Current Zoning: N1-A (Neighborhood 1)
Proposed Zoning: UR-2(CD) (Urban Residential, Conditional)

Approximately 19.75 acres located on the north side of Choate Circle between Legree Lane and Freshwell Road.

The petition proposes to allow redevelopment of a site in the Steele Creek community with a multifamily residential community containing 350 dwelling units and accessory uses.

Staff recommends approval of this petition upon resolution of outstanding issues related to transportation and site and building design.

**RZ.01**

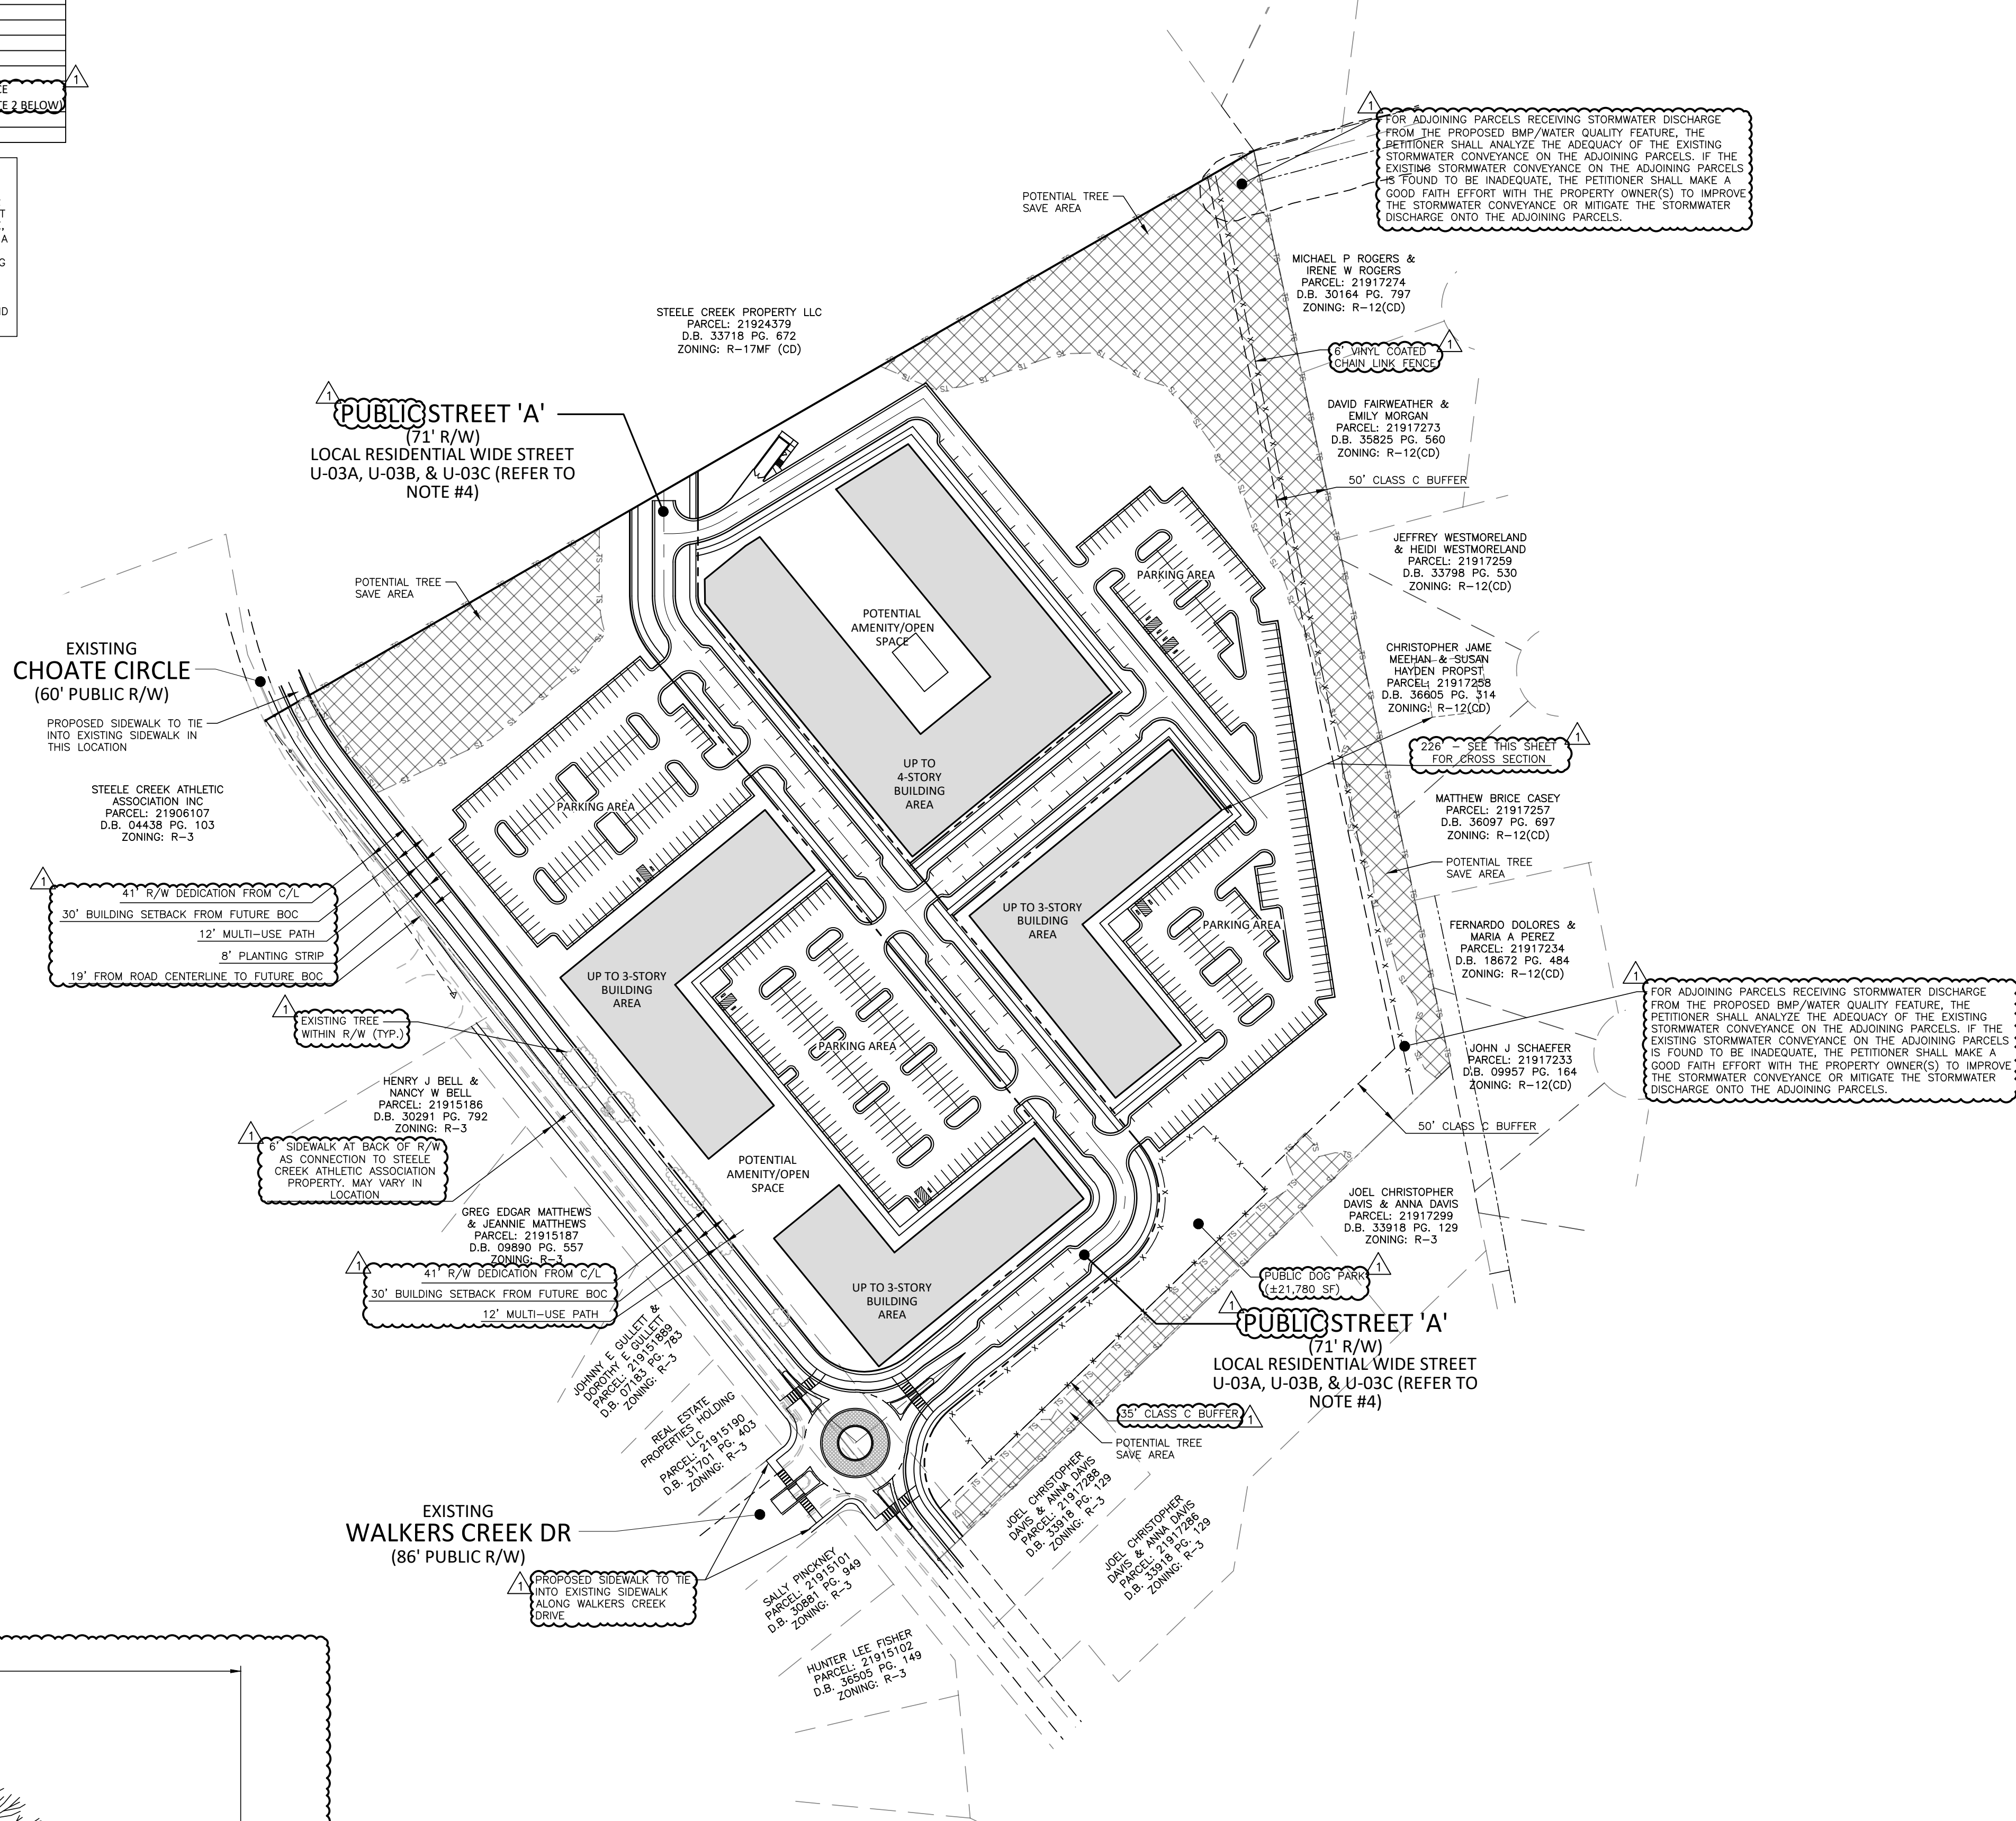
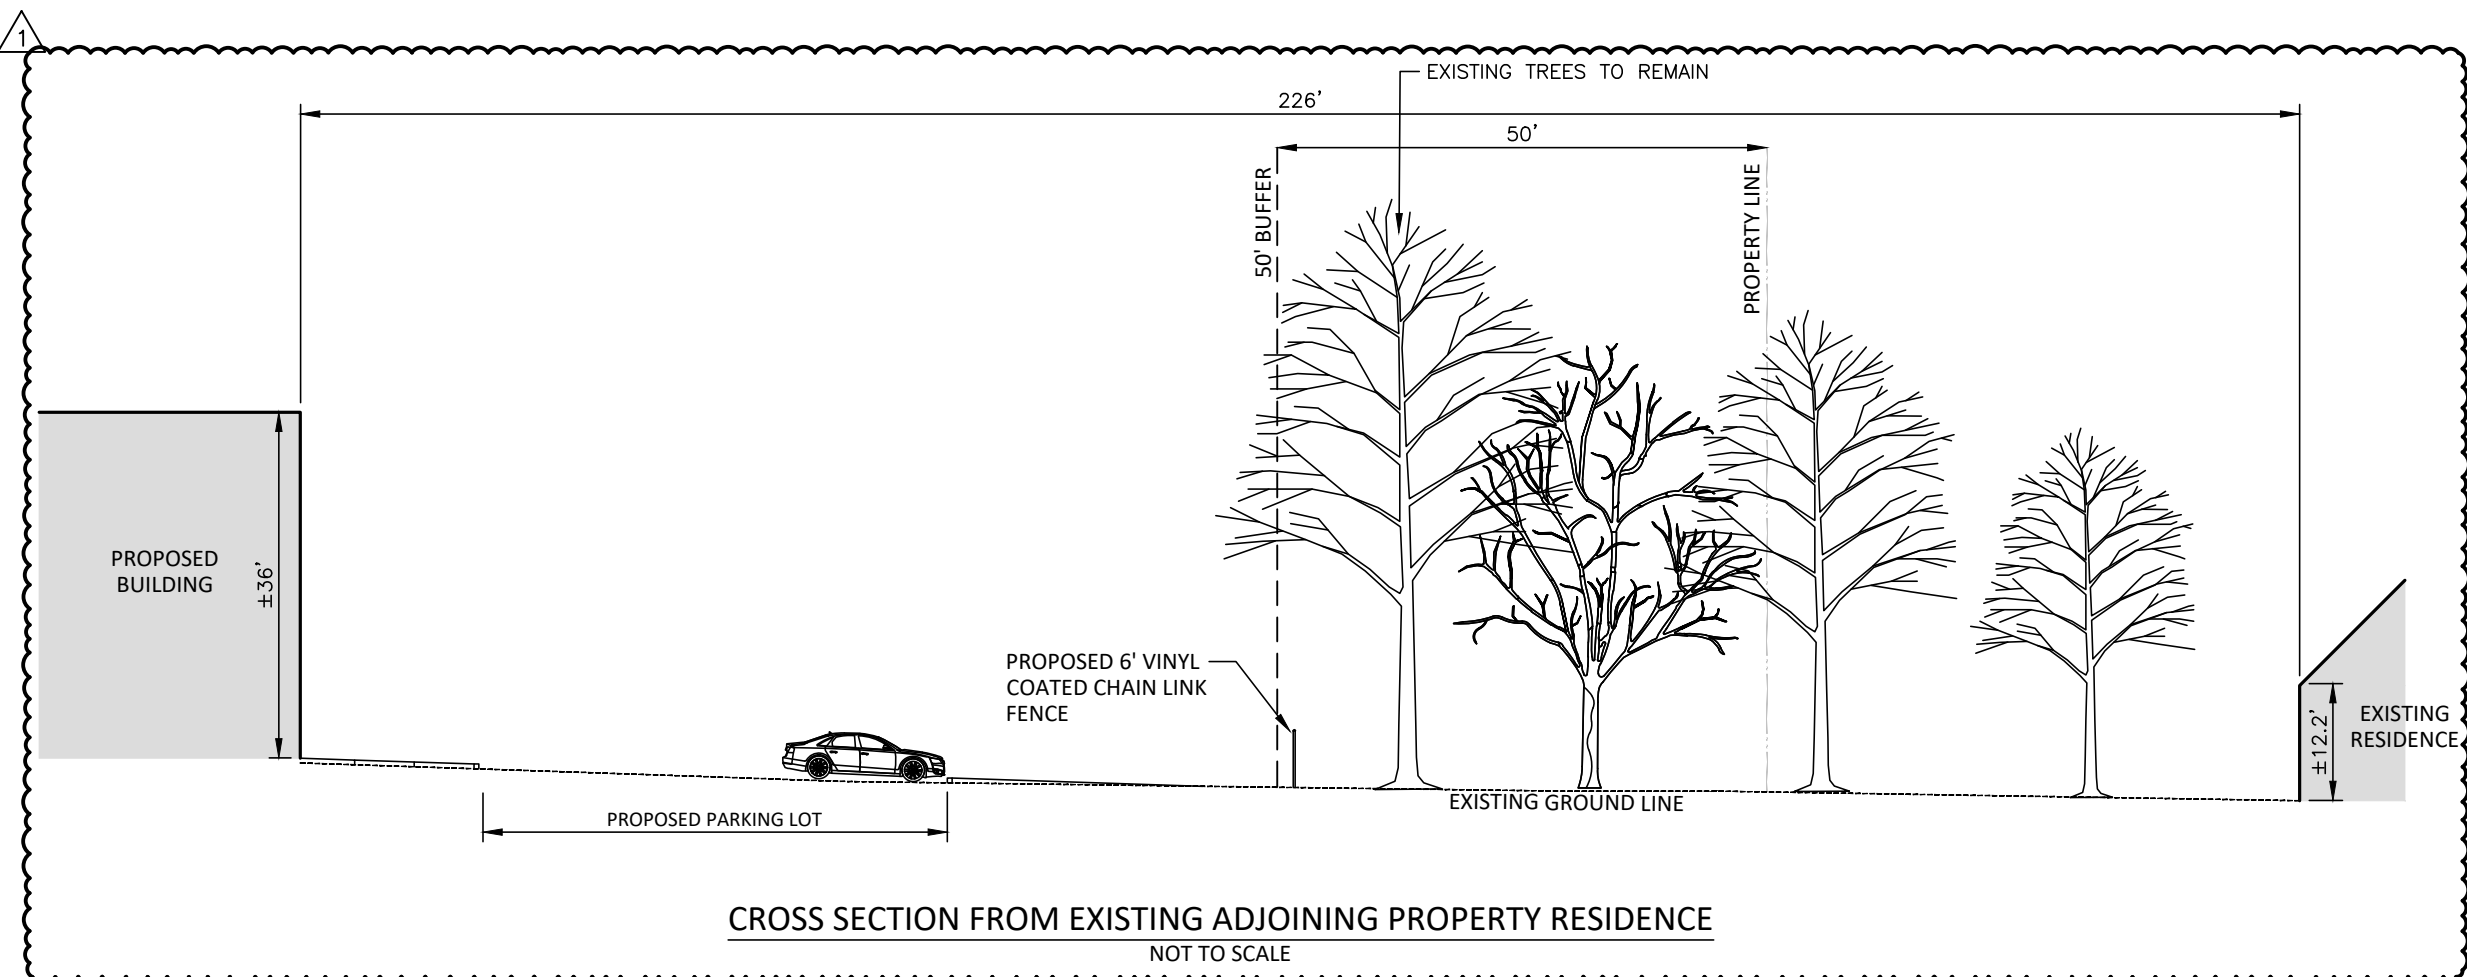
1. Revise the site plan and conditional notes to convert the proposed private streets to public streets.

2. Provide tree survey identifying all trees of eight-inch DBH or greater and all planted trees of two-inch caliper or greater and six feet in height that grow partially or wholly within the city right-of-way.
3. Delete the word "building" from setback note on site plan.
4. Delete the second sentence of note 4.c stating "The proposed Class C buffers may be made of existing vegetation and new vegetation".
